Your Ref: OWPC3323
Our Ref: EP/108/14/HH 11-07-2014
Please ask for:
Mr D Sullivan

Removal of thatch roof of detached garage & replace with clay roofing tiles.
Resubmission of EP/29/14/

The House on the Bend 15 Sea Lane East Preston

EXISTING ELEVATIONS OF THATCHED GARAGE

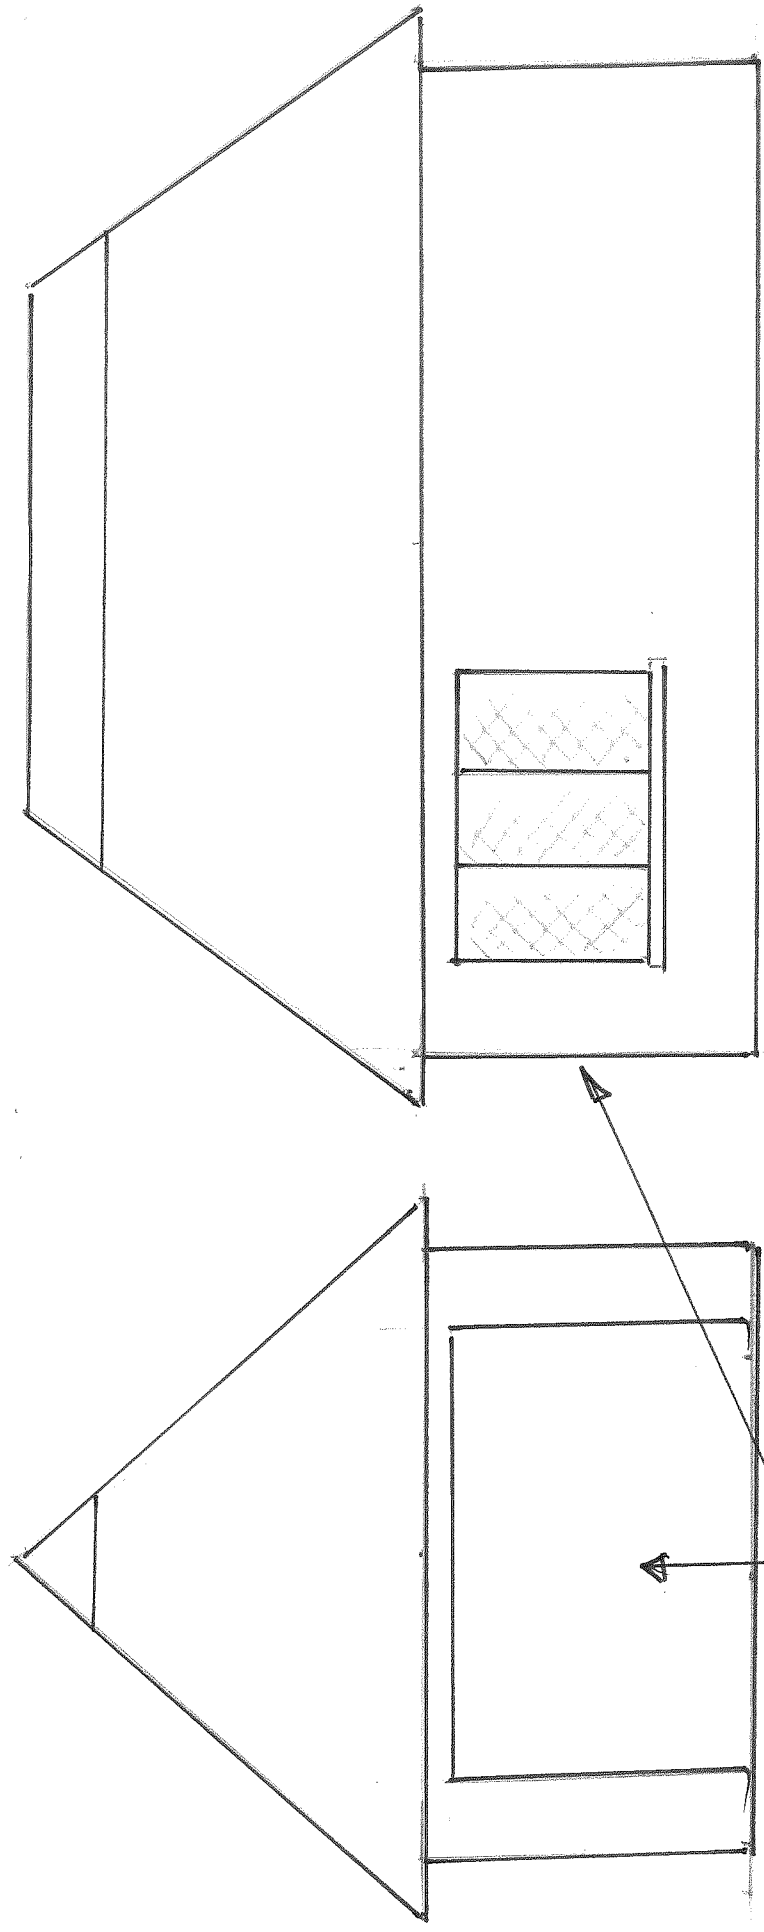
The proposal to replace the original thatched roof of this building, a former outbuilding of the House on the Bend from its days as a farmhouse, is clearly contrary to Policy GEN22 of the 2003 Arun Local Plan and to Policy DM26 of the emerging Local Plan. The thatched roof is an original feature of the building. It is a feature that contributes significantly to the building's architectural and historic interest, and its removal would detract significantly from the building's appearance. The removal of the thatched roof would also have a substantially detrimental effect on the street scene; the building directly abuts the road, and provides a small reminder of the agricultural past of the village. Removal of its original thatched roof would detract from its character and its appearance.

GARAGE
EXISTING ROOF THATCHED

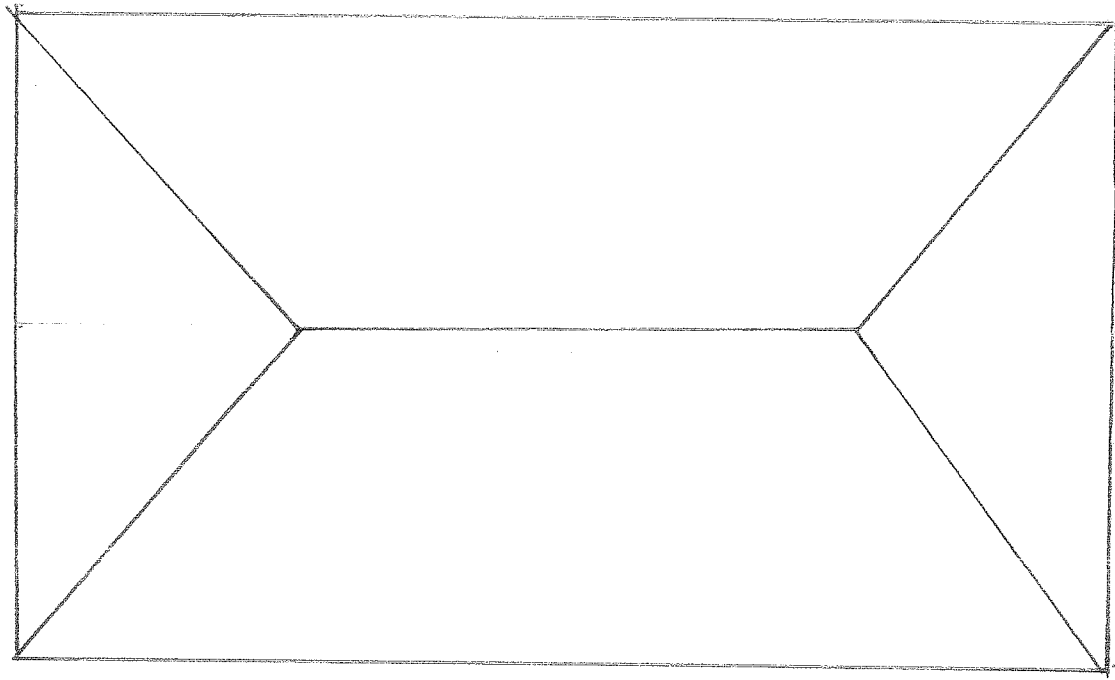
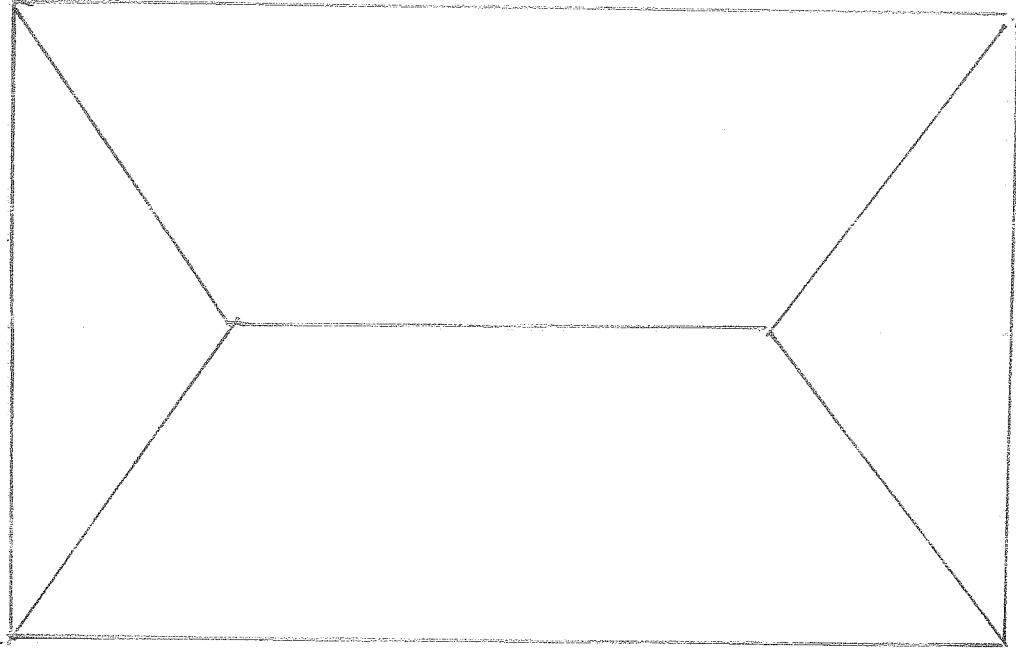
Replacing the thatched roof by tiles would subvert the purpose of including this building on the Local List. Permission for the change should be refused. If the thatched roof leaks, it should be re-thatched.
